DESIGNERS RESPONSE

Lady Ann Road, Batley, Kirklees

Road Safety Audit Stage 1

2022-12 Batley RSA1 – Revision 0

R3 Long Section  
Scale X 1:100  
Scale Y 1:500

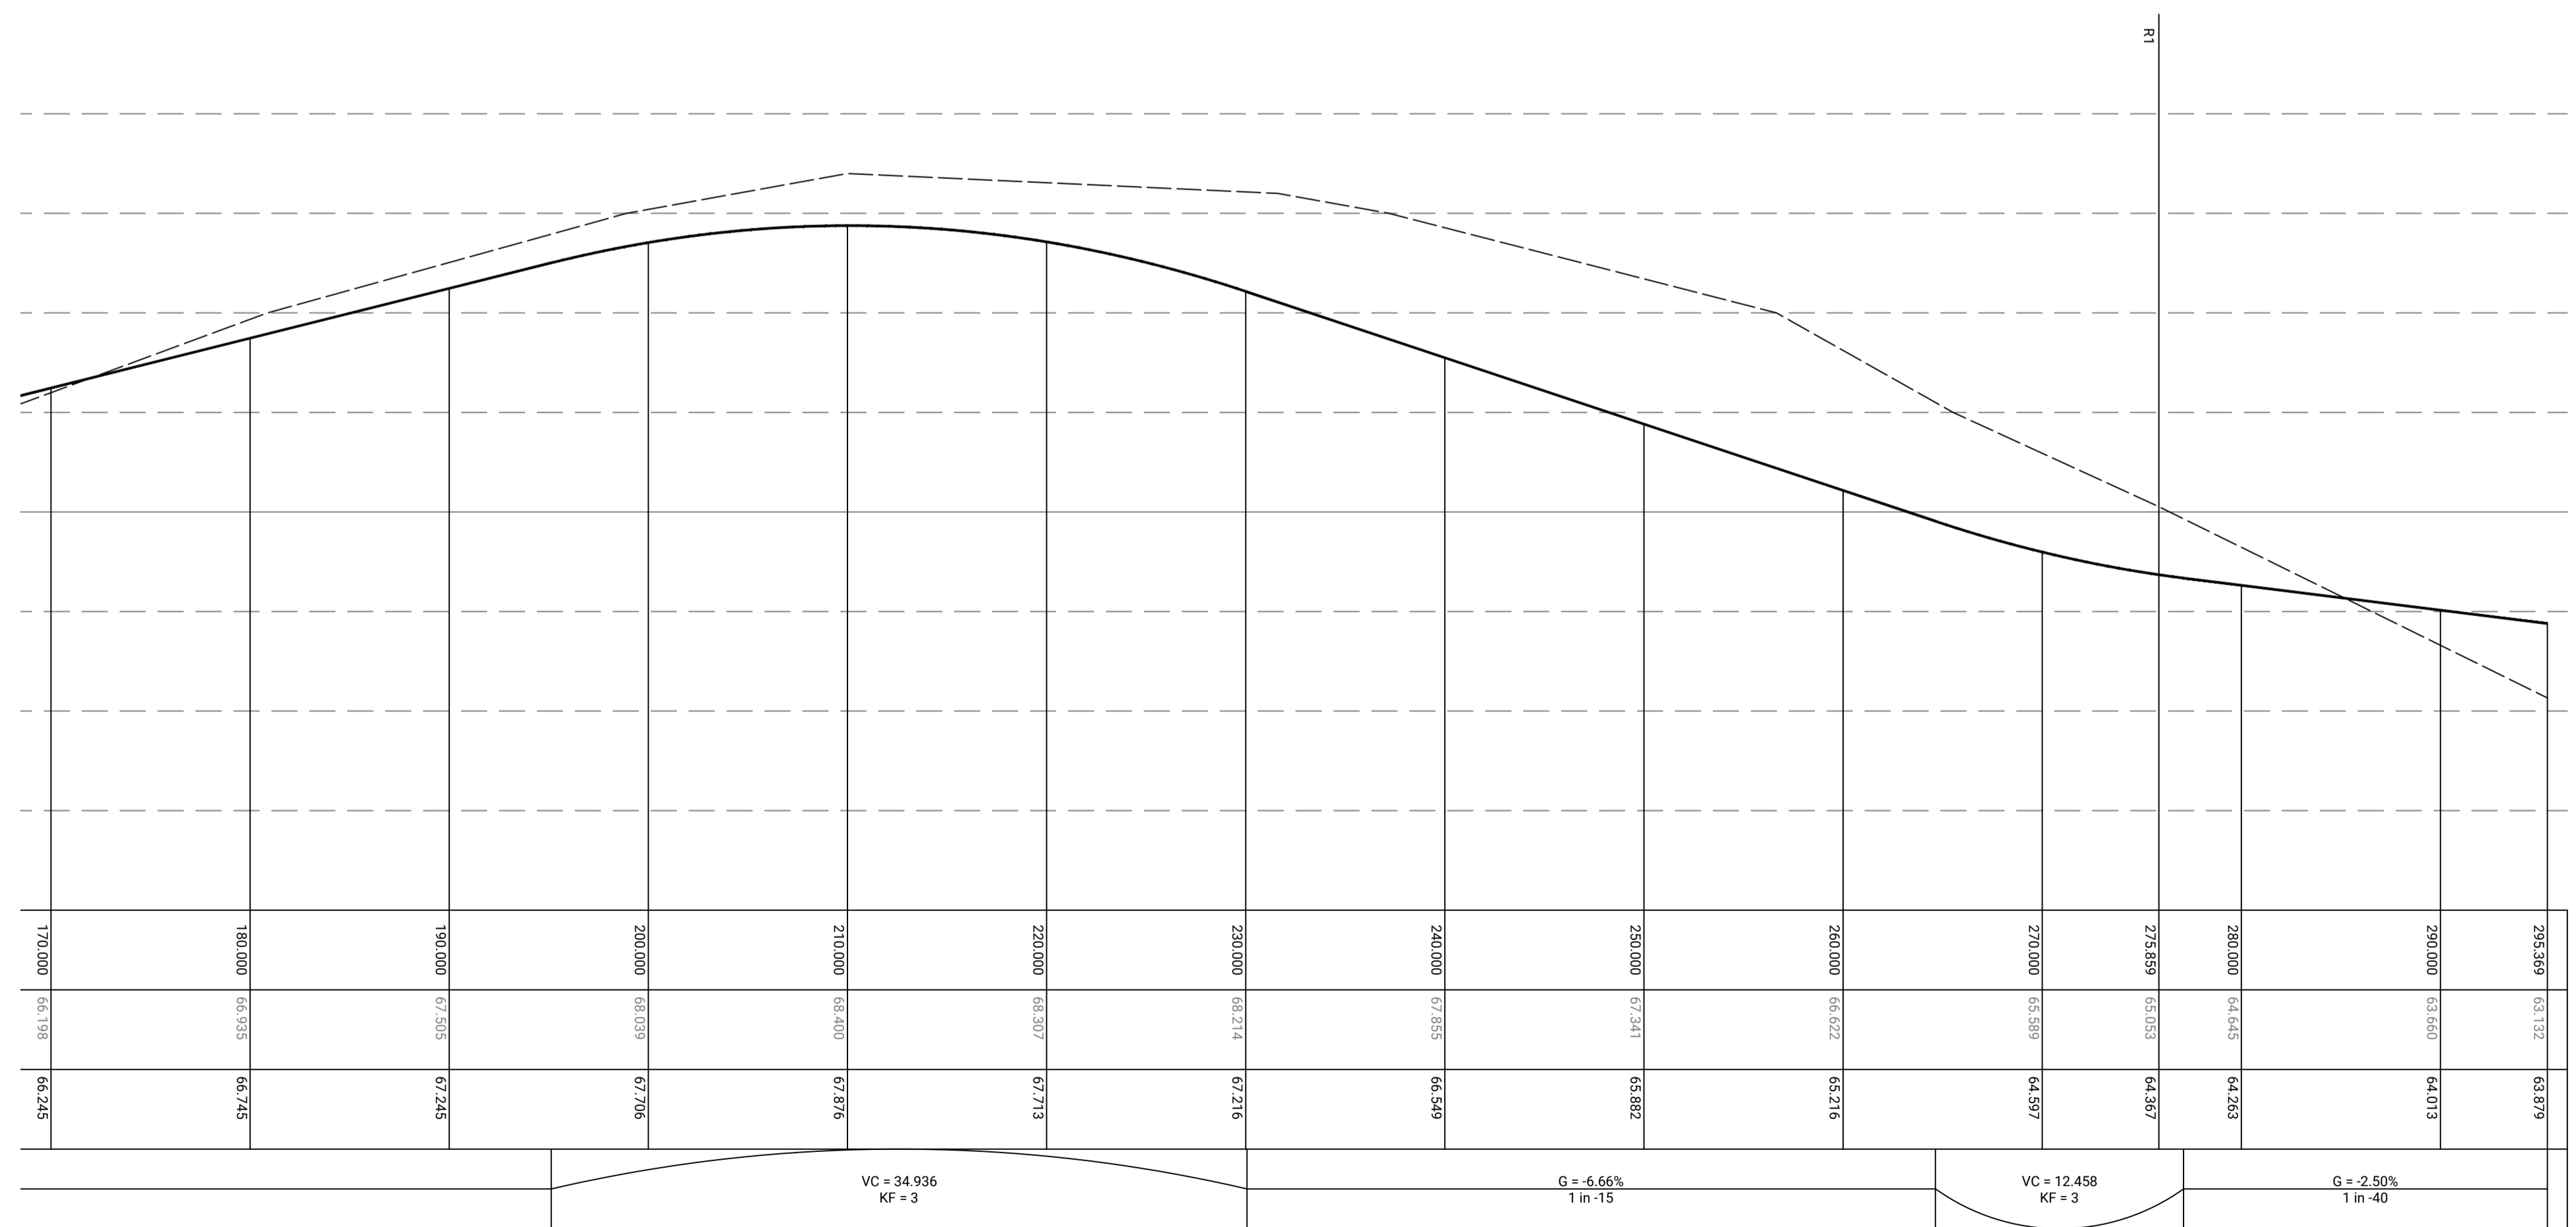
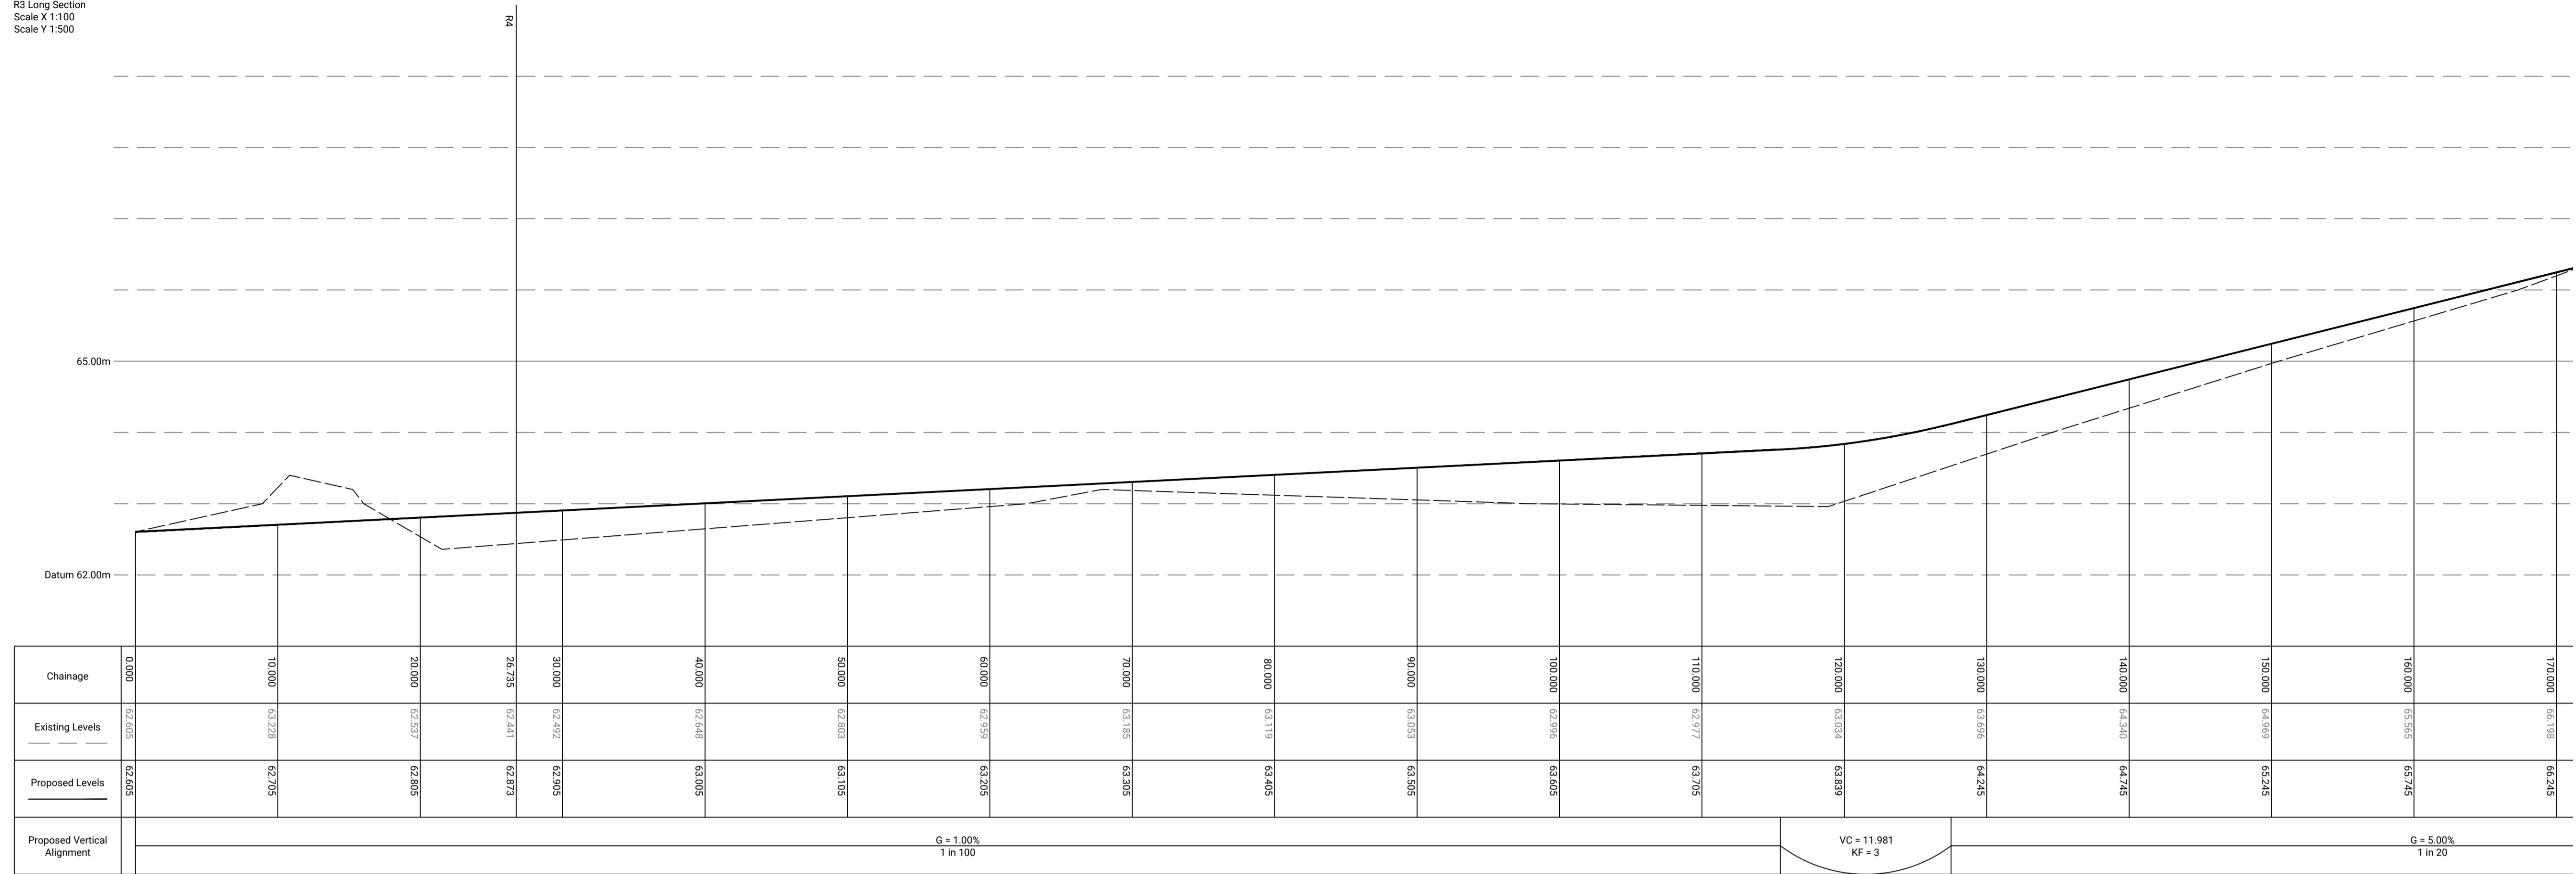
No details have been provided of the polished stone values (PSV) of the bituminous materials, especially with consideration of the proposed estate road gradient fronting plots 57 to 63, which appears to be about 1 in 10, although the north south road also appears to have steep gradients. In addition, there are likely to be inspection chamber covers on gradients and near junctions. Inappropriate carriageway construction with low PSV values or covers with a low PSV may increase the risk of overshoot, rear shunt or pedestrian accidents, and may also increase the risk of skid/loss of control type collisions for powered two-wheel users.

Partially Accepted – road surfacing shall meet the Council’s adoptable specifications
